**Our Ref: BN/15/13/
Your Ref:**

Application for Planning Permission for Works or Extension to a Dwelling

Development Ground floor front and rear extensions and other minor refurbishment works.
Location 6 Halliford Drive Barnham Bognor Regis

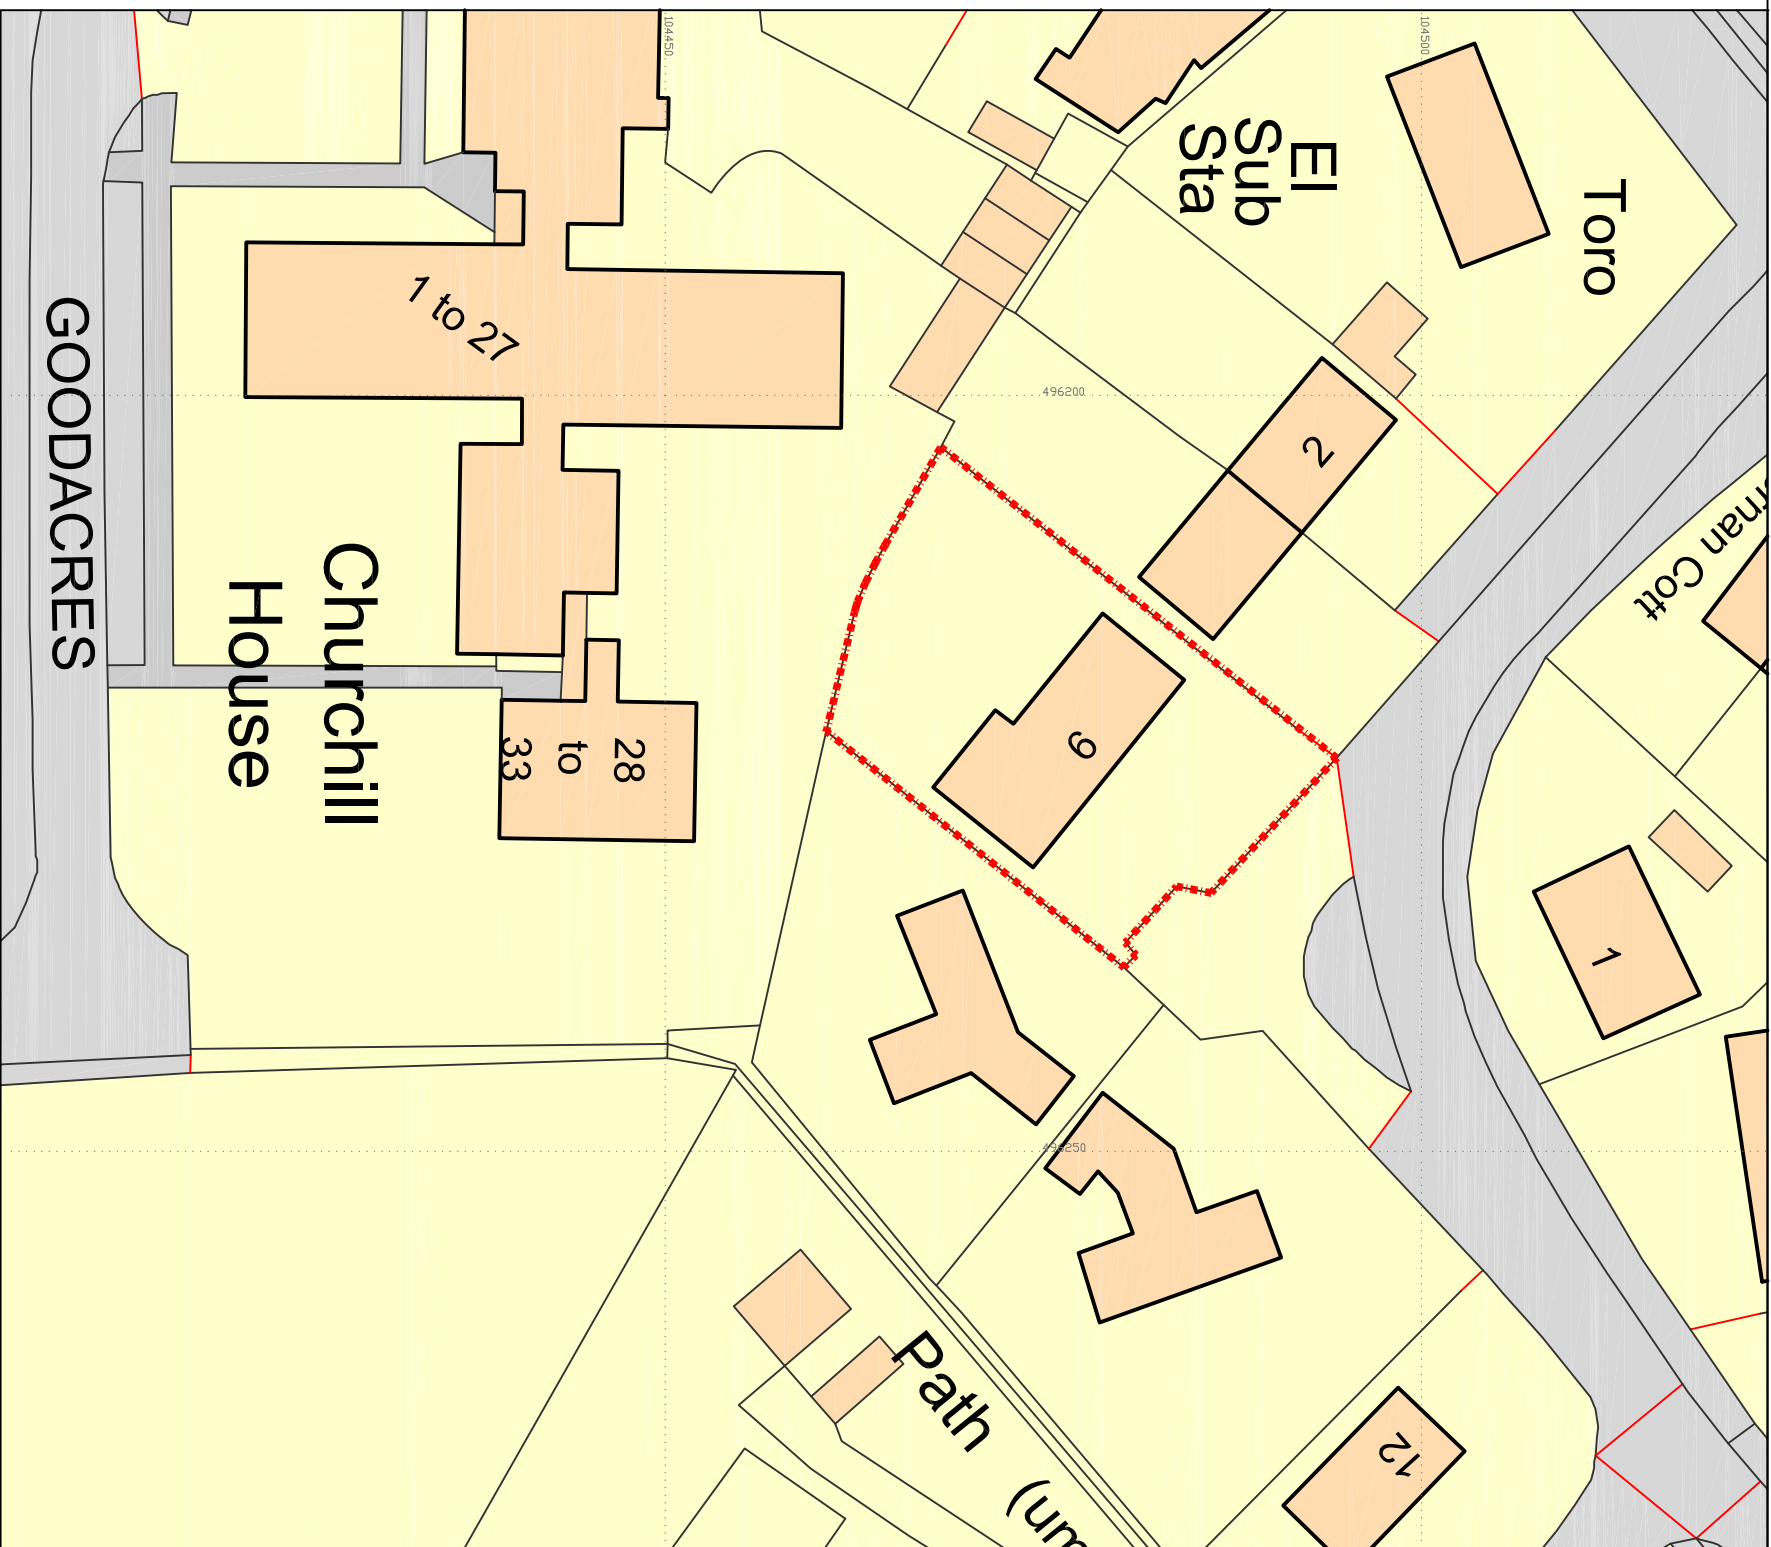
Please submit 1 electronic or 3 paper copies of an amended block/site plan to include the proposed extensions clearly highlighted/hatched in accordance with the guidance notes available on our website detailed below (click on National List).

DRAWING TITLE
SITE PLAN AS PROPOSED

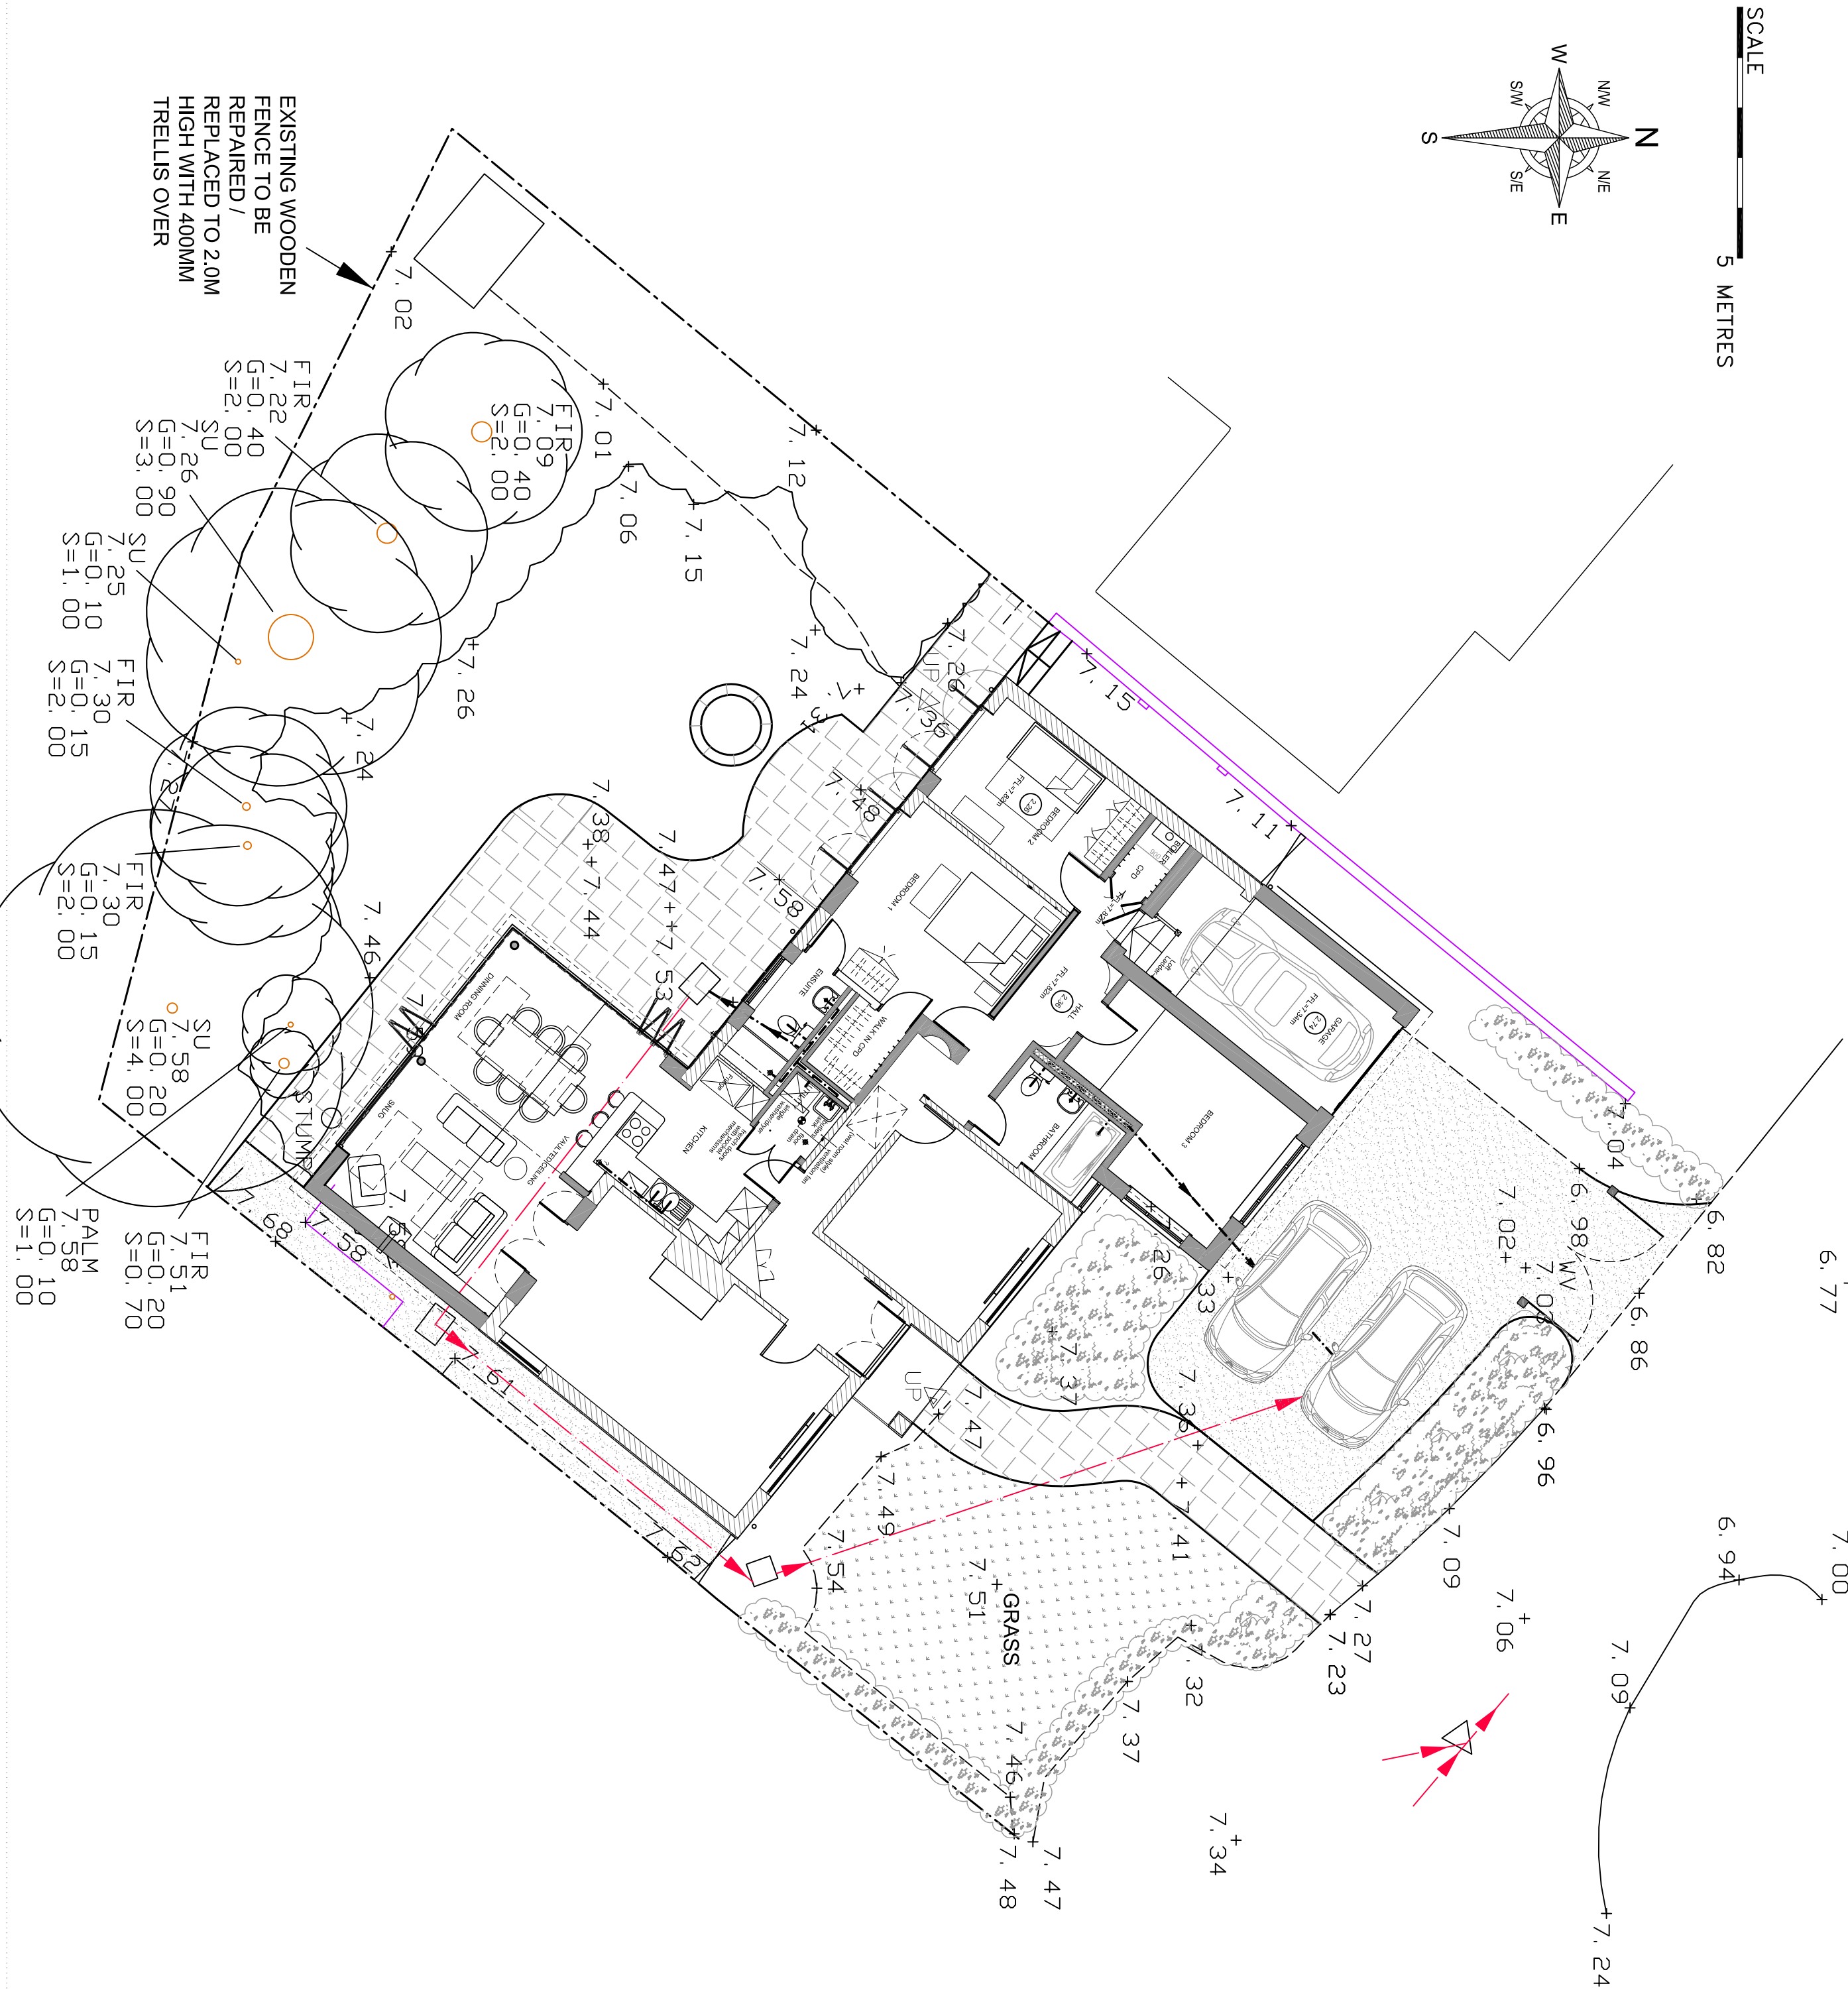
Please submit 1 electronic or 3 paper copies of existing and proposed roof plans in accordance with guidance notes available on our website detailed below (click on National List).
